Planning Application Ref: WA/22/19/PL

Location: The White Cottage, West Walberton Lane, Walberton, BN18 0QS

Description of works: Demolition of existing dwelling & erection of 1 No. replacement dwelling (amendment to WA/49/18/PL).

Comments on Application:

Proposed Extension and Alterations
at White Cottage, West Walberton Lane, Walberton
for Mr. and Mrs. A. Wickland
Drawing CD01 March 2019 Scale 1:200 @A3
Planning Drawing - Tree Protection Measures

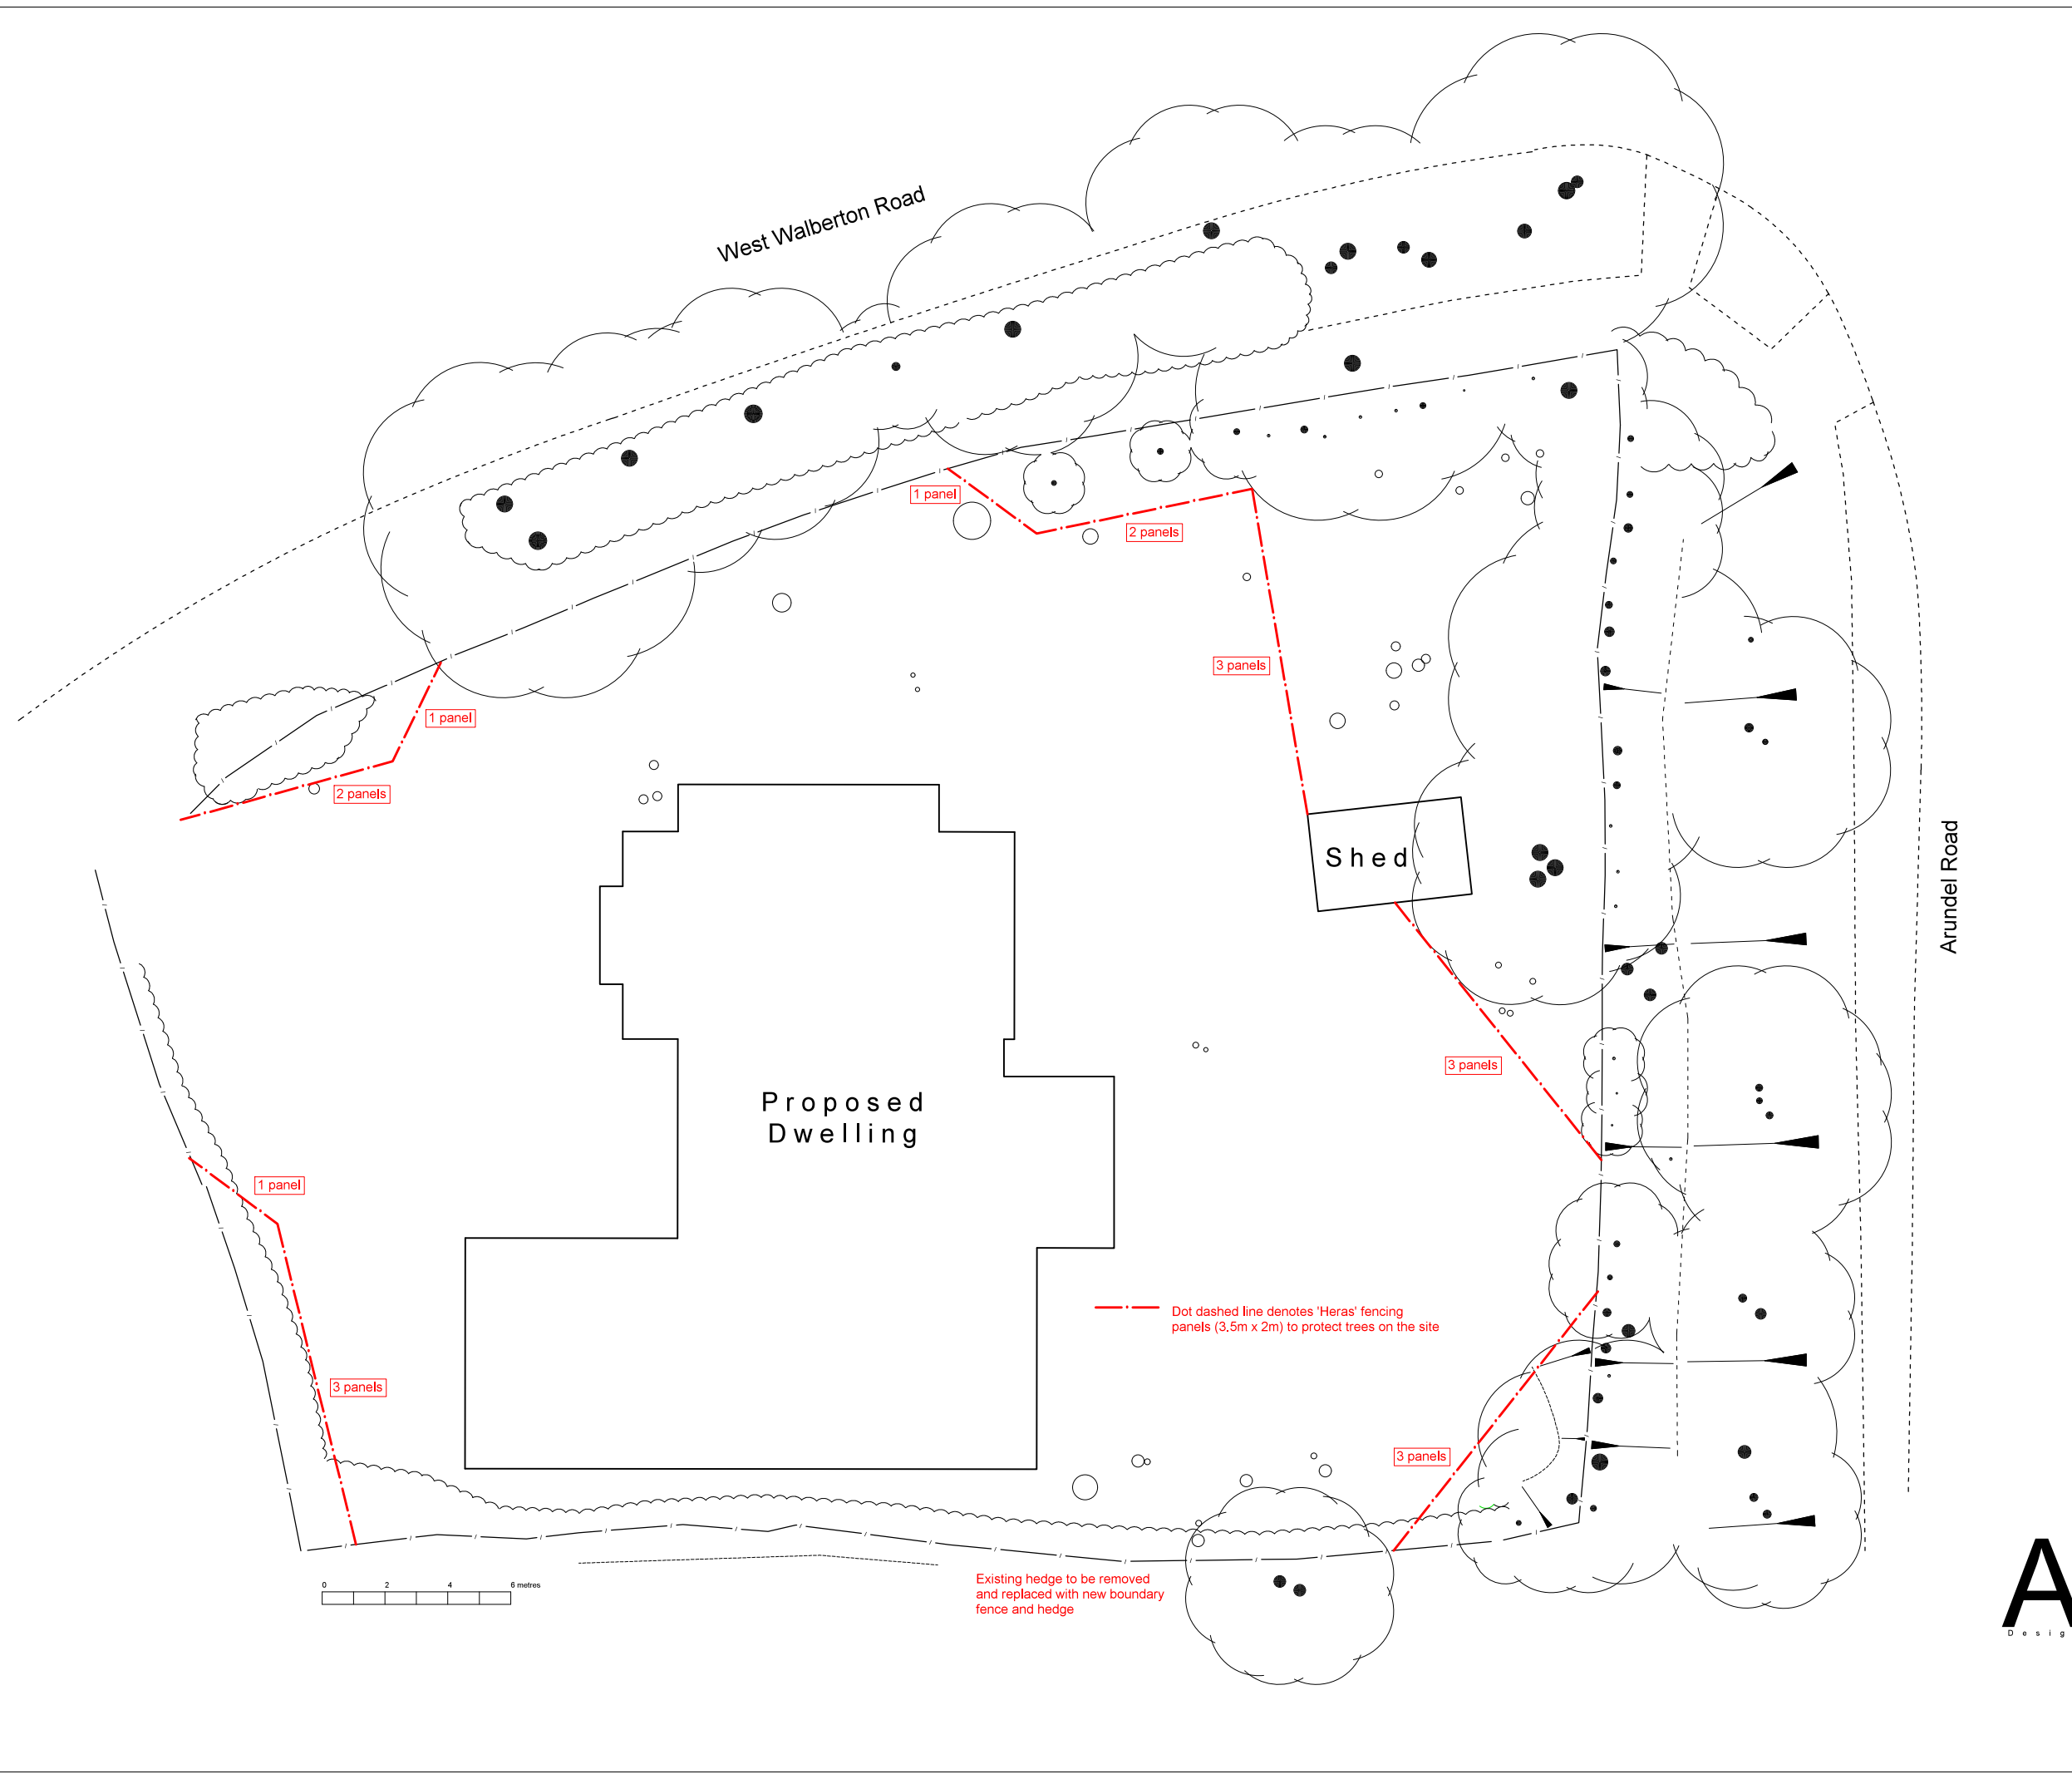
- The sole item of arboricultural information provided, *Planning Drawing – Tree Protection Measures*, dwg. CD01, provided by Architectura, is only indicative of where fencing would be positioned and is not supported by a tree survey and root protection area schedule. This falls a long way short of what is required at this application stage.

- The applicants will need to employ the services of an Arboricultural Consultant to carry out a tree survey exercise and then prepare an Arboricultural Implications Assessment (AIA) which must be inclusive of; a 'Tree Survey Schedule', a 'Root Protection Area (RPA) Schedule' and a 'Tree Constraints Plan' – with the trees accurately plotted on same.

- In the event that a RPA of any tree which is proposed for retention overlaps the development then BS5837:2012 requires that the Detailed Planning Application is accompanied by an Arboricultural Method Statement (AMS) and also most importantly a Tree Protection Plan – to both describe and illustrate the mitigation measures which are to be employed to ensure that the trees survive without detriment to their vigour and vitality and are given adequate protection both above and below ground.
